Office
of Water

6 October 2009

Subject: Major Project 05_0129 'Lakes Estate' 198 Lot Residential Subdivision at Lakes Drive and North Boambee, North Boambee Valley, Coffs Harbour

**Lakes Estate Catchment
Area Stormwater Constraints**

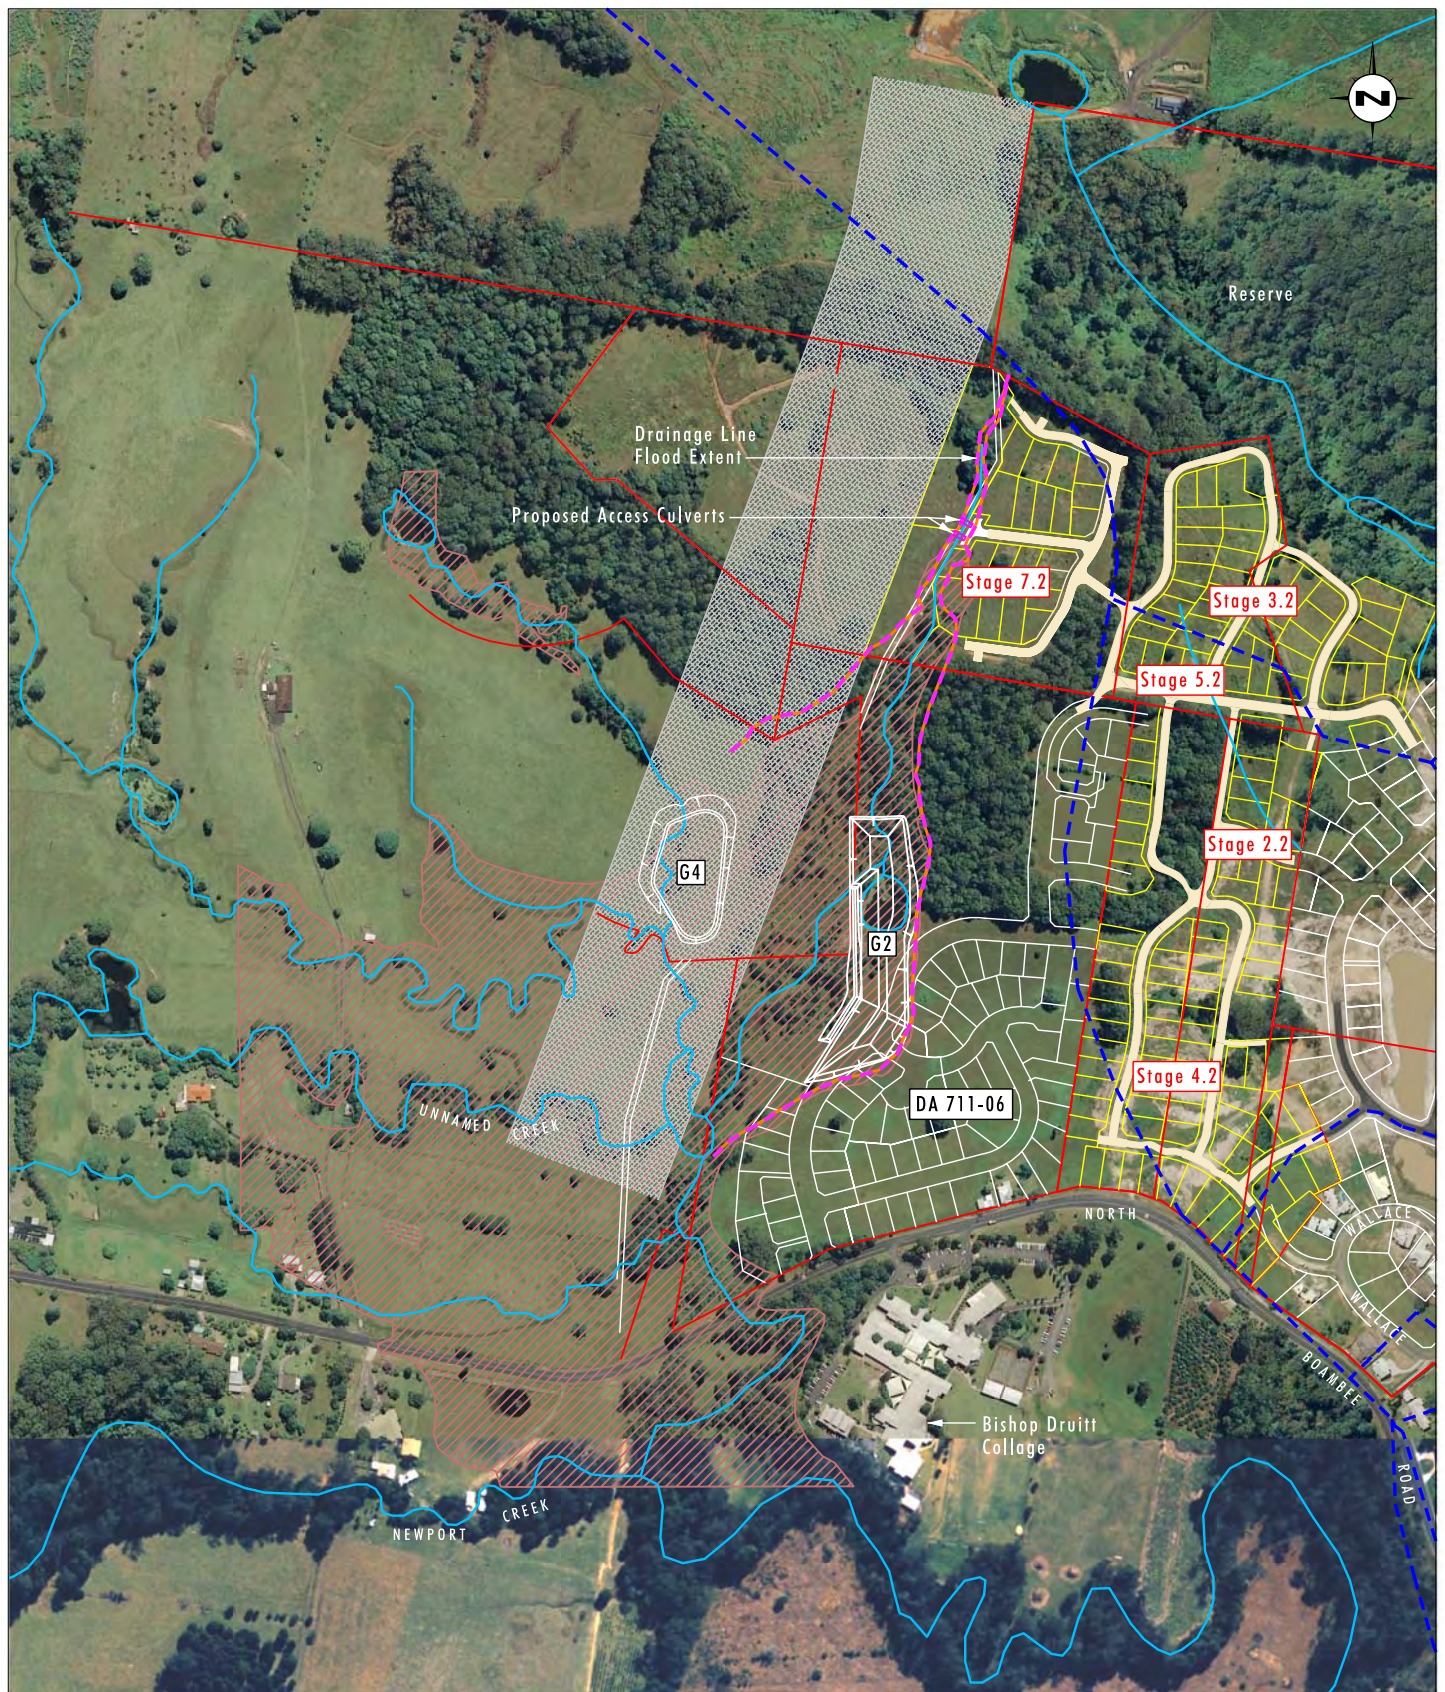
NOW has concerns with some of the proposed riparian works associated with the development. The proposal to extend the existing approved channel upstream of Lake 5 to the existing dam upstream of Stage 3.2 in particular is not supported by NOW. This area has a well vegetated natural riparian corridor and is in an area zoned 7A for Environmental Protection. NOW supports the retention of the natural functioning riparian corridor across the site, including the retention/ establishment of an appropriate Core Riparian Zone (CRZ) and Vegetated Buffer (VB). Asset Protection Zones (APZ) for bushfire protection must be located outside of the CRZ and VB, in conjunction with the 'Guidelines for Controlled Activities' under the *Water Management Act 2000*. I have attached a copy of the guidelines for your information.

It also appears lots in Stage 3.2 are located across the watercourse and in the area zoned 7A for Environmental Protection, in particular lots 150 and 151. The proposal may have to be modified to remove lots in Stage 3.2 of the development, which interfere with the natural drainage line to maintain natural flows and the integrity of the watercourse.

**Western Catchment Area
Stormwater Constraints**

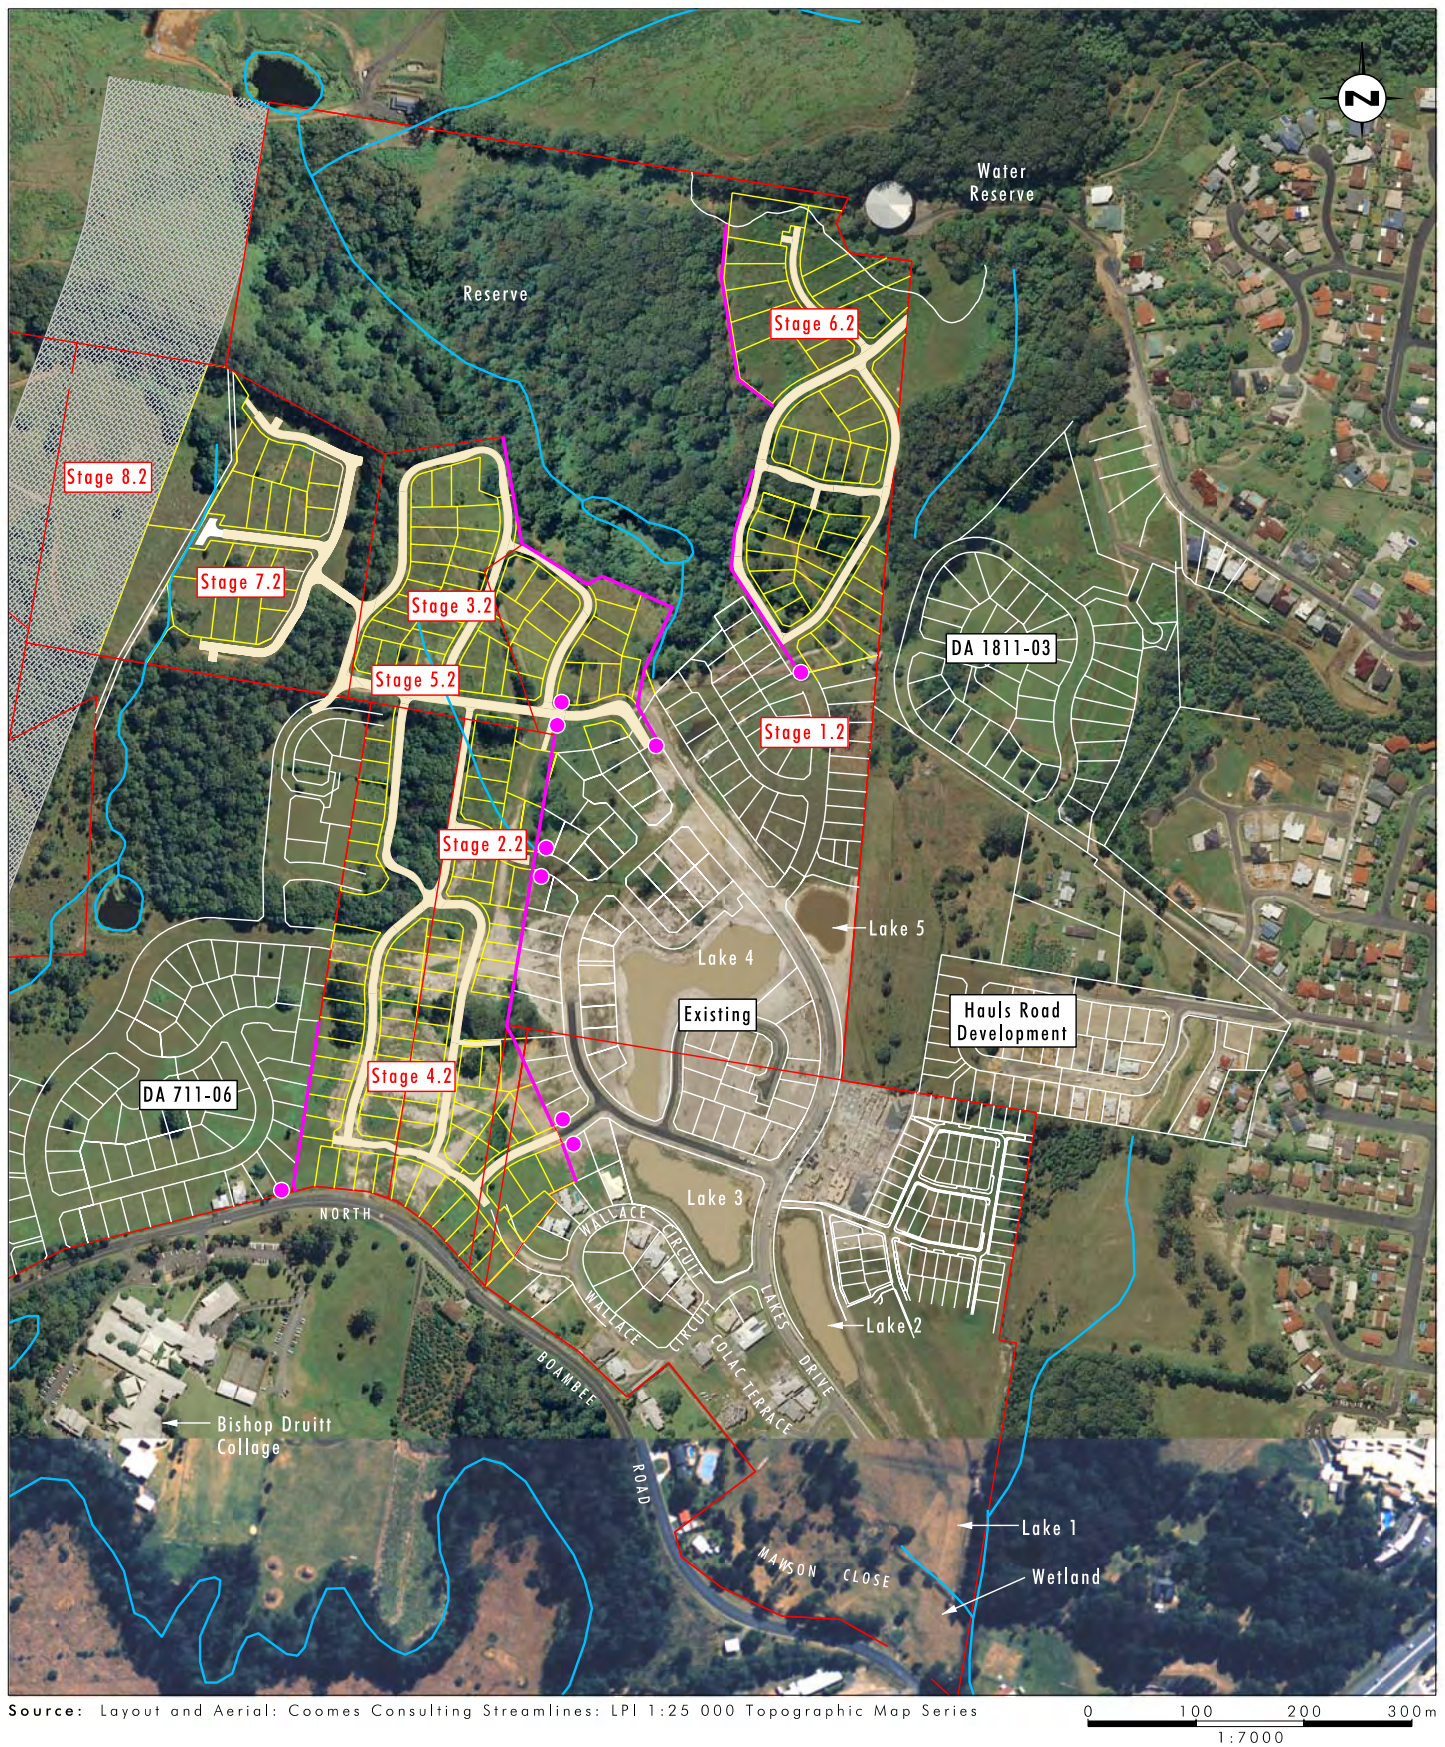
The construction of the culvert must be consistent with our guidelines and must maintain existing or natural hydraulic, hydrologic, geomorphic and ecological functions of the existing watercourse.
